24 February 2012

**Re: Pasminco Cockle Creek Remediation (06\_0184 Mod 3)**

Graeme Nyland  
Contaminated Sites Auditor

Figure 1: Concept of proposed geocomposite capping system

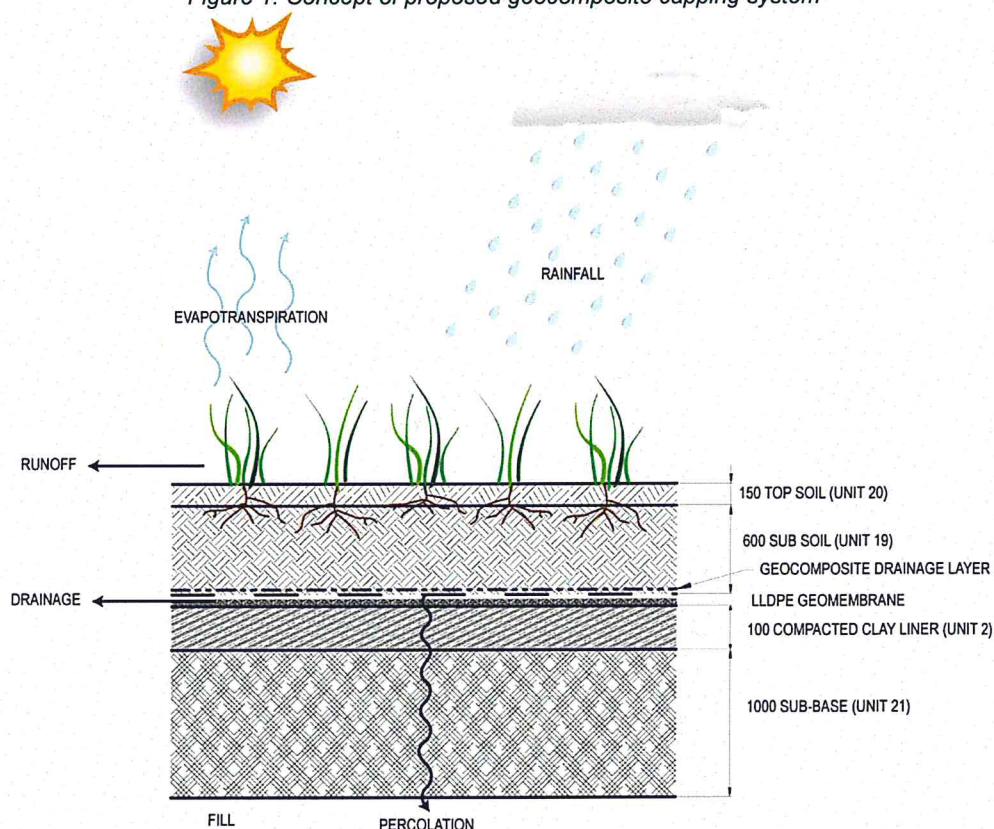
Comments: The geomembrane should be able to provide equivalent performance to the clay cap.

Comments: The geosynthetic drainage system should be able to provide adequate drainage.

Comments: While this proposed change could increase infiltration, the capping and drainage system if properly designed should ensure that there is no increase in leachate generated.
